Redfern Local Area Command

2nd February 2015

Mixed use Student accommodation development at 60-78 Regent St, Redfern (SSD 6724)

LANEWAY FAÇADE

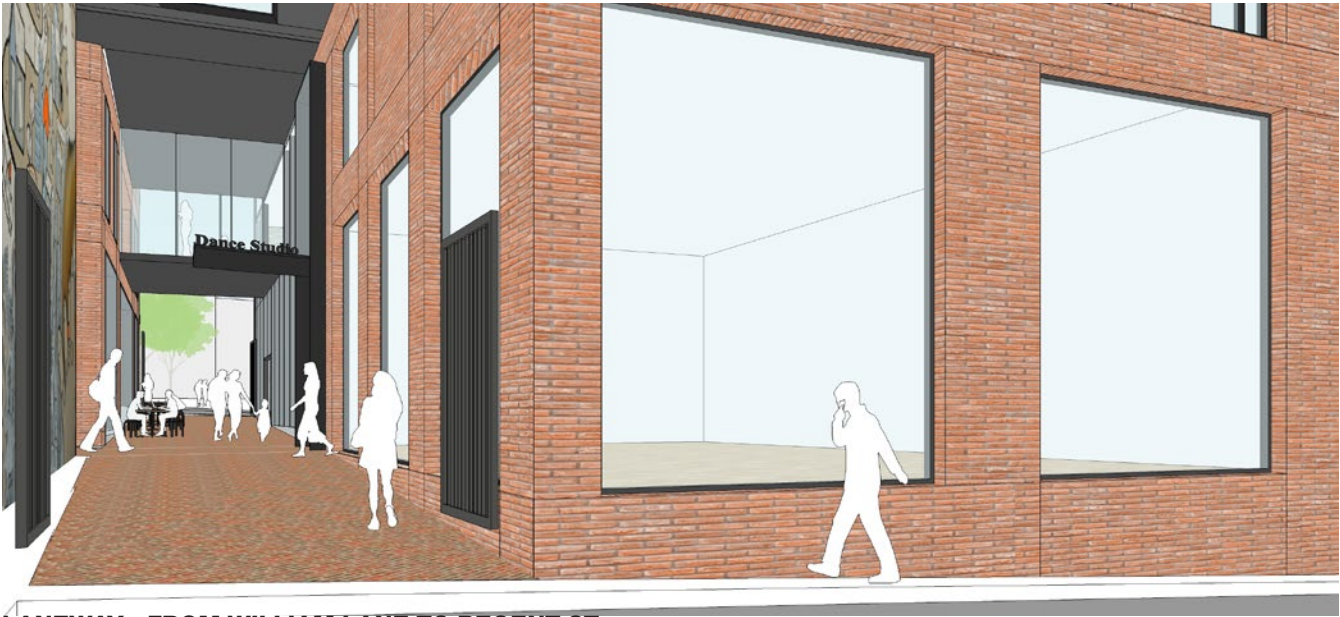
- By ensuring clear sightlines, the opportunity to commit a crime is decreased, in the retail laneway area; this can be achieved by installing security gates that allow passing pedestrians to view into but not access.

- At the T-intersection in the laneway area, a mirror should be installed to allow pedestrians to view around the corner. This will allow the pedestrians walking along the laneway area to view around the corner to ensure their safety when utilising this area.

- Police suggest that automatic lighting be installed in the bicycle area on the ground floor. This will allow people entering the room to know if there is another person in the area. This will deter potential crimes (robberies/sexual assaults/stealing) occurring in this area.
- Lighting in William Lane to be installed if the access way is to be implemented. William Lane has poor night lighting with many areas of concealment, making it a vulnerable area for crimes against person (robberies, stealing and assaults).
- The laneway area is to be well lit allowing passer-byes to see into the laneway providing the area with more natural surveillance.

- Police strongly suggest that all access to William Lane at the rear of the development be blocked off from the public. After discussions with the developers and IGLU Director it was identified that this lane area leading the William Lane will be of little use to the occupants of the building. By accessing William Lane it provides potential offenders another access area to a poorly lit area. William Lane is a small access lane way to the underground car park of the neighboring Dei Corp building. Alternates to the William Lane access would be to extend the dance Studio on the ground level or 2 large locked gates at the corner of the laneway and on the curb in William lane. This will prevent all potential crimes from occurring in this location.
